From: Peart, Timothy - Communities <Timothy.Peart@Oxfordshire.gov.uk>
Sent: 28 November 2019 10:48
To: Matthew Chadwick <Matthew.Chadwick@Cherwell-DC.gov.uk>
Subject: RE: 19/02261/DISC - Swalcliffe Park Equestrain Ltd Swalcliffe Park Equestrian Park Lane Swalcliffe OX15 5EU

Planning application:	19/02261/DISC
Location:	Swalcliffe Park Equestrain Ltd Swalcliffe Park Equestrian Park Lane Swalcliffe OX15 5EU
Description:	Discharge of conditions 3 (Construction Traffic Management Plan) 4 (landscaping scheme) & 6 (biodiversity method statement) of 19/00171/F
Type:	Discharge Of Conditions
Case Officer:	Matthew Chadwick

Condition 3 – The Highway Authority objects to the application to discharge condition at this time as further information is required.

**Detailed description of construction routes from Taylor Farms & external roadways to site of vet building.**

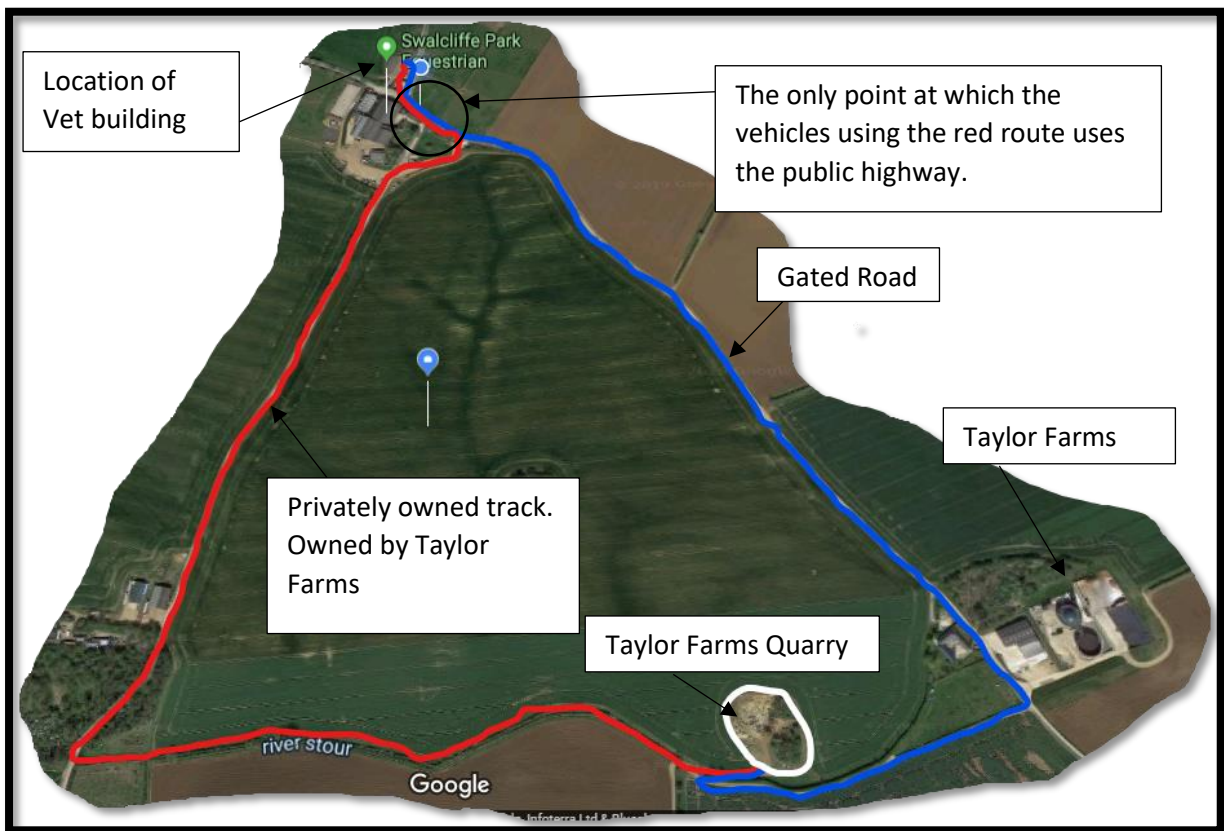
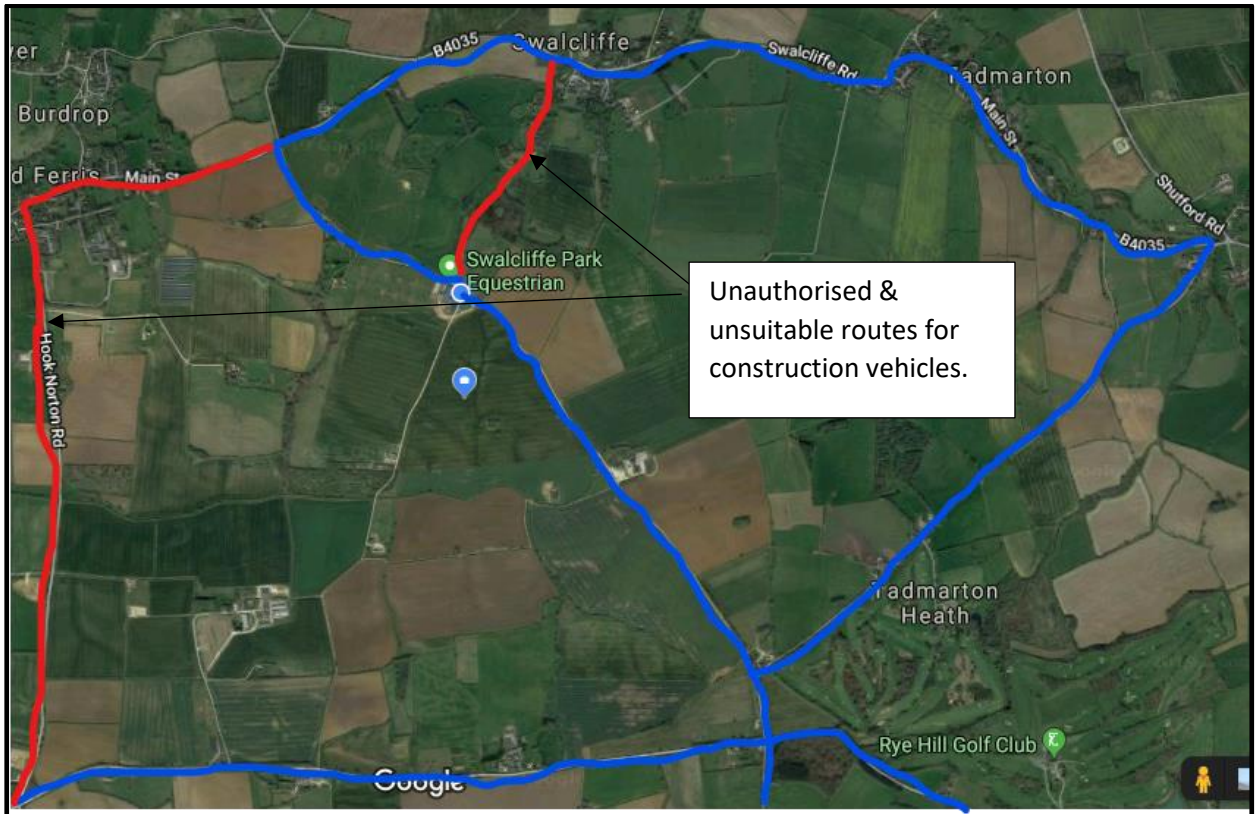
While I note the relatively small scale of construction works required in this fairly isolated location and that where possible materials will be locally sourced, I would however like to see details of construction routes to and from the site for building and plant materials to ensure that unsuitable routes are avoided.

I would also request that delivery times are restricted to between 09:30 and 16:30 to limit the impact of construction traffic on the wider highway network.
